From: Joshua Hollis <joshua.hollis@cbrk.com.au>
Sent: Tuesday, 10 March 2020 5:31 PM
To: Rosie Sutcliffe
Cc: 'einnnes@munnnsslymoore.com.au'; Greg Carmichael
<Greg.Carmichael@ctpg.com.au> (Greg.Carmichael@ctpg.com.au)
Subject: Austral school: set-down/pick-up spaces

The department's letter of 9th December 2019 in relation to the proposed school includes the following:

1 CAR AND BICYCLE PARKING PLAN
1 : 1000

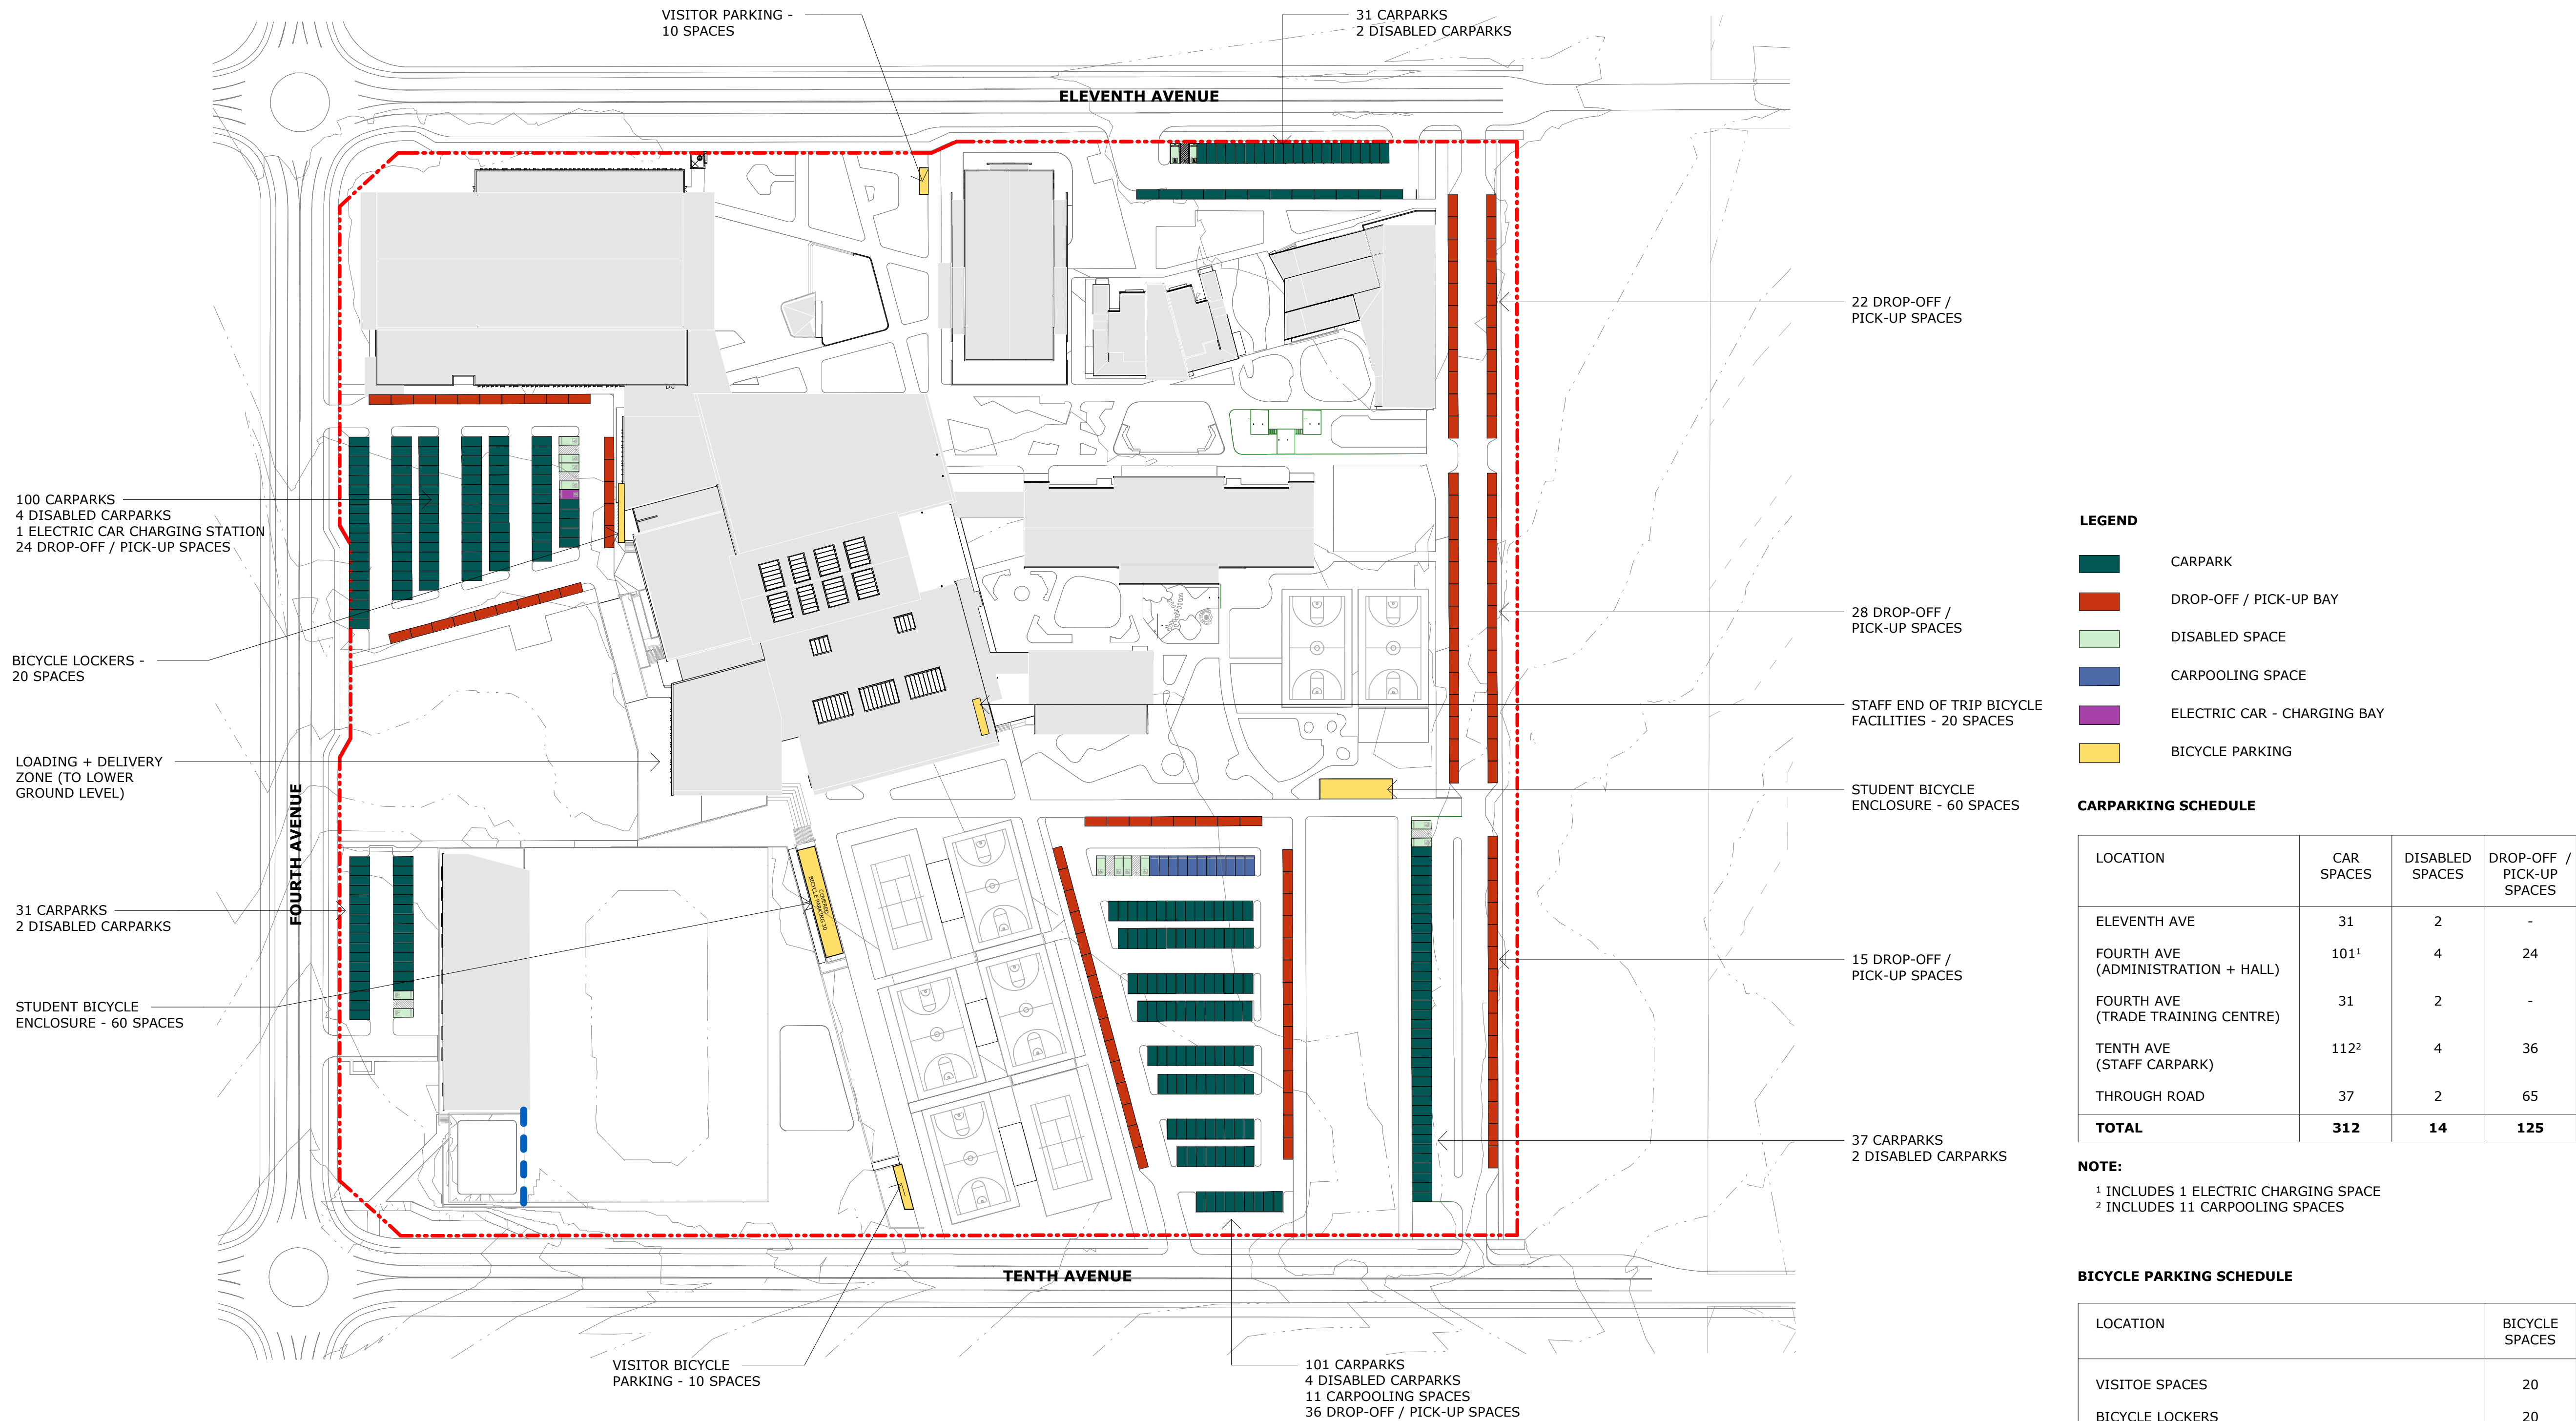
- *the Traffic Assessment Report states that there are 147 on-site drop-off and pick up spaces. However, the RtS and plans indicate a total of 125 spaces.*

We note that there have been a number of iterations to the plans since the application was lodged in 2018. We confirm that current plans include 125 parking spaces for set-down and pick-up, as noted by the department.

The provision of 125 spaces for set-down and pick-up operations will cater for activities at the school. The proposed provision is one space per 20 students, which is consistent with the provision at other schools.
